CITY OF ALBUQUERQUE

April 26, 2024

**Re: Dunkin Restaurant
1600 Eubank Blvd NE
Site Plan
Engineer's Stamp 4-10-24 (J21D004A)**

C102

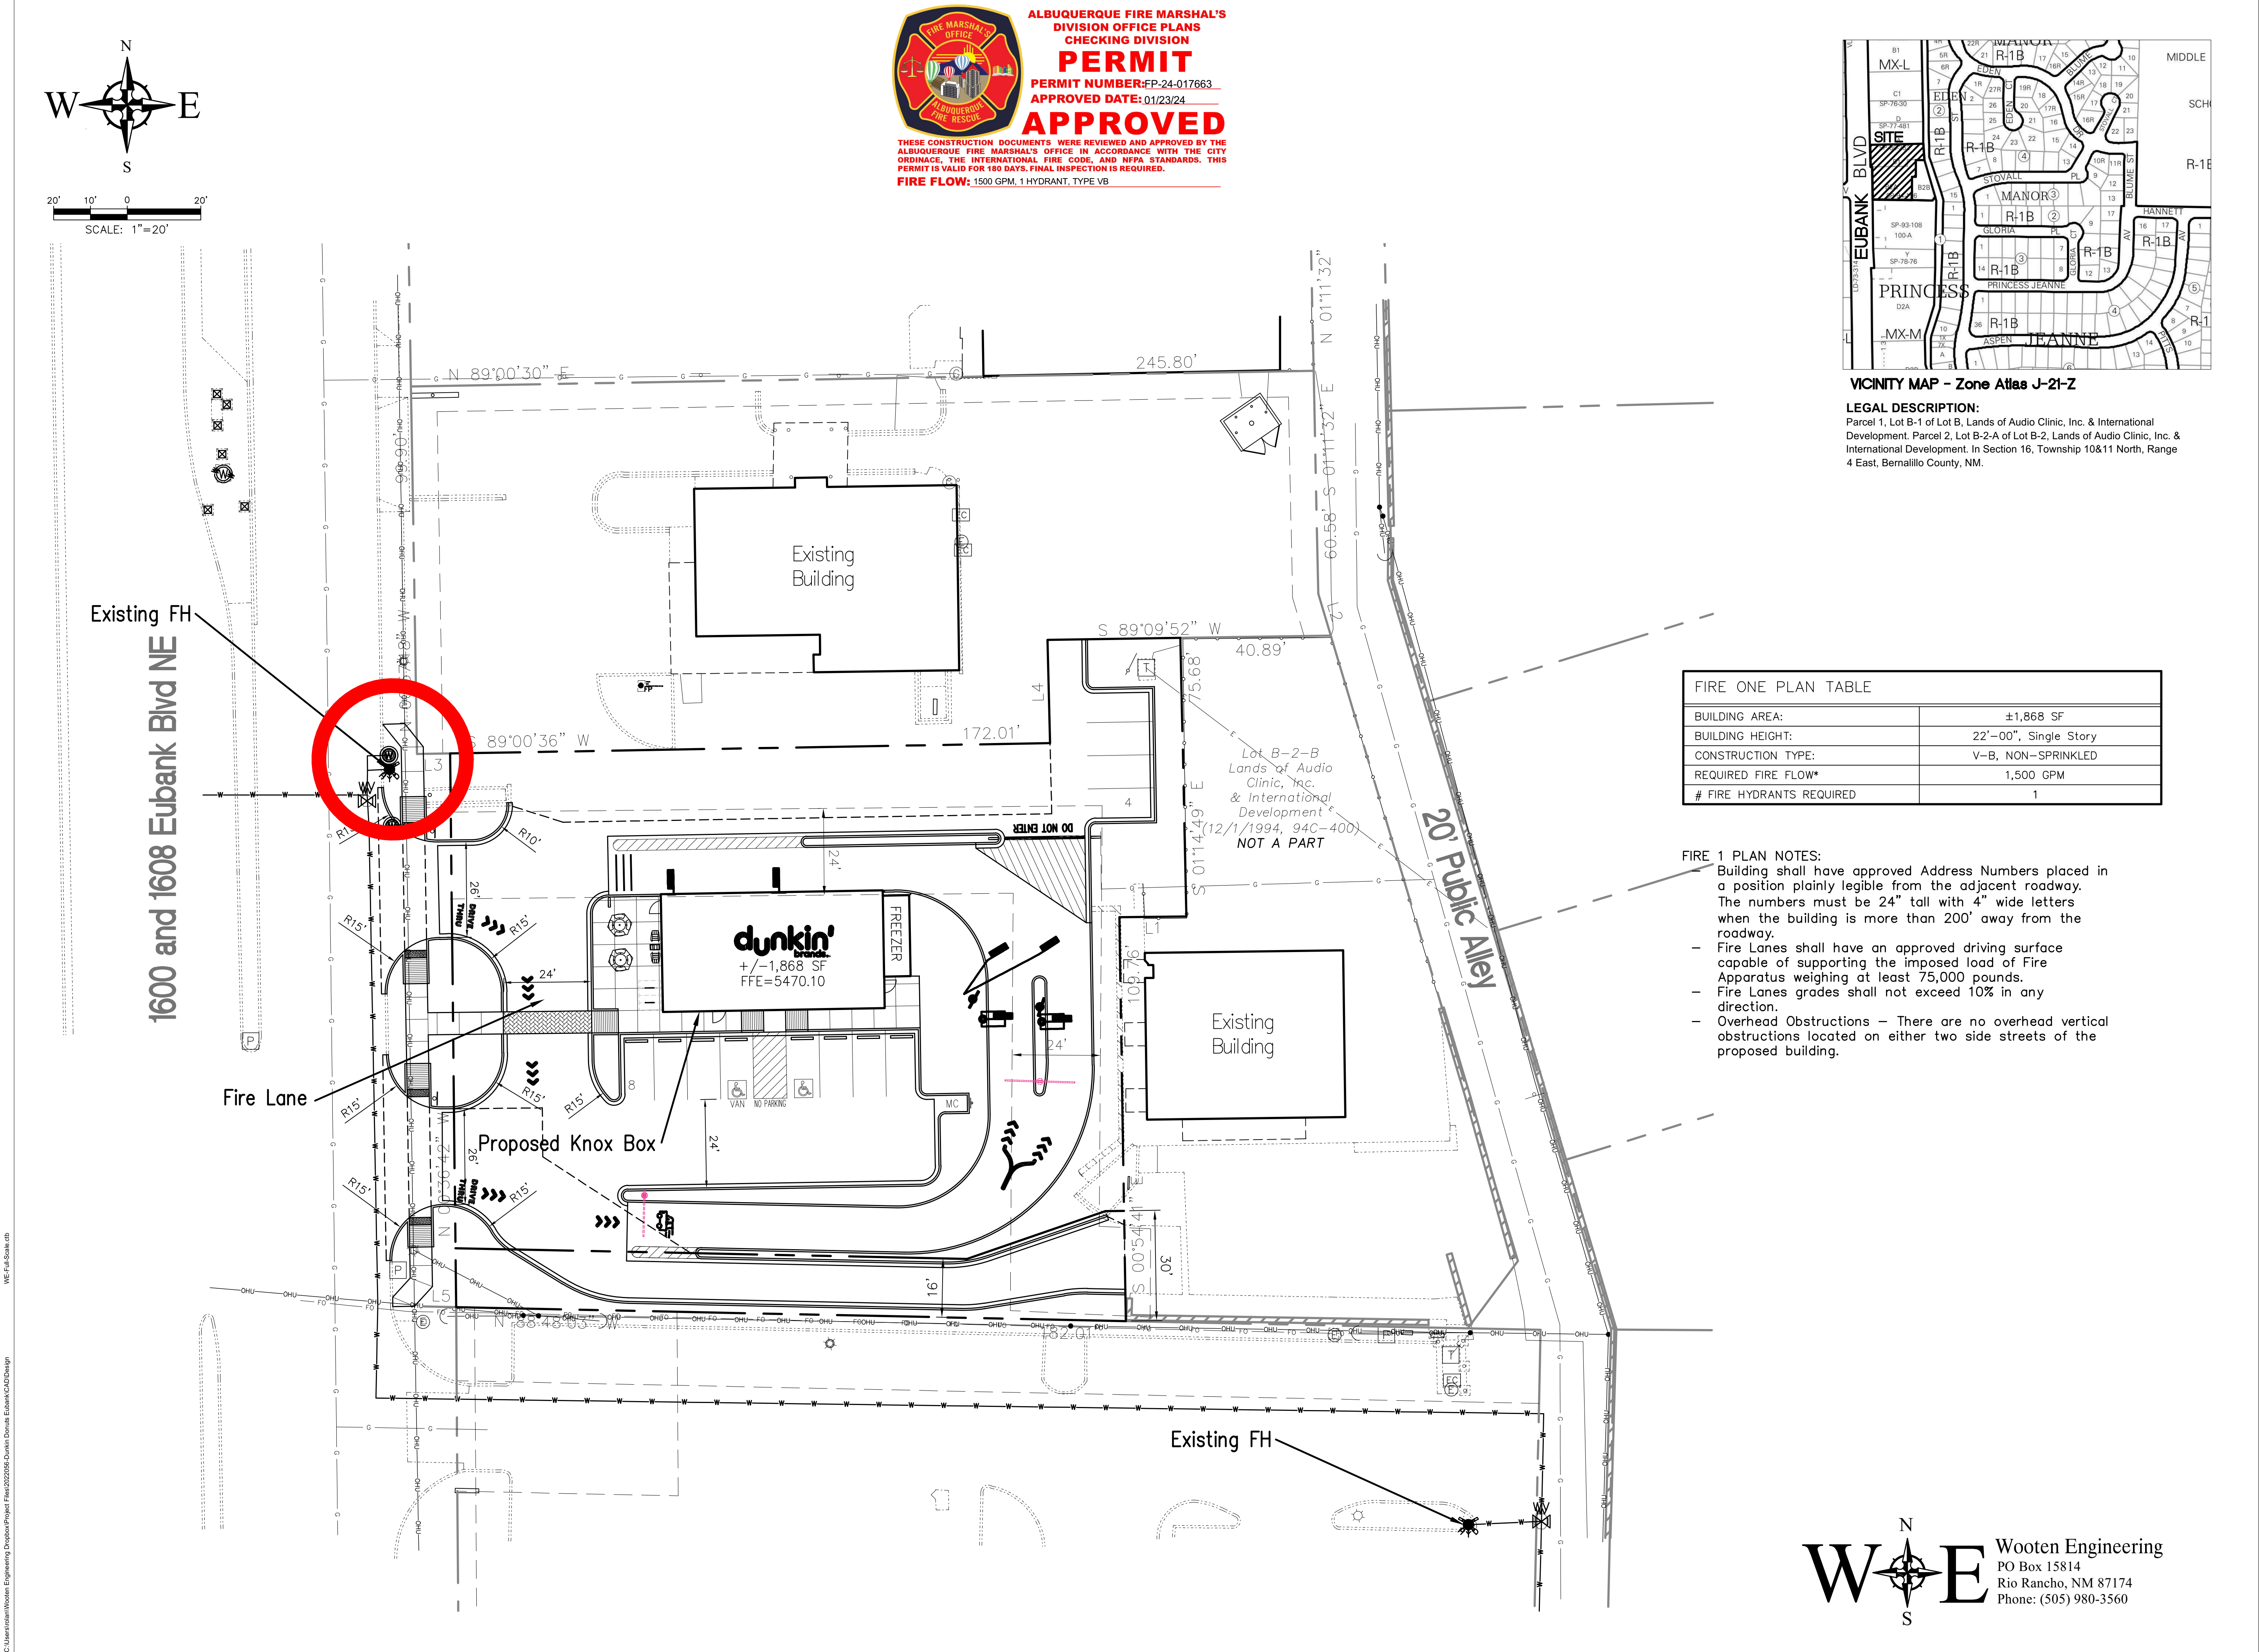
6. Please update the required parking table as parking required for restaurants is 5.6/1000 sq. ft. The amount of provided parking is acceptable.
7. The minimum number of bicycle parking is 3 spaces. Please update the parking table. Please revise the bike parking detail on Sheet C102 to show the length of a bicycle parking space of 6 feet plus a 1 foot buffer on each end for a total of 8 feet.

10. The STOP sign , Keyed Note 21, should be moved to the private side of the property line.
11. Dimension the motorcycle parking space.
12. It would help the Contractor to show the size and lettering for the motorcycle sign on Sheet C102.
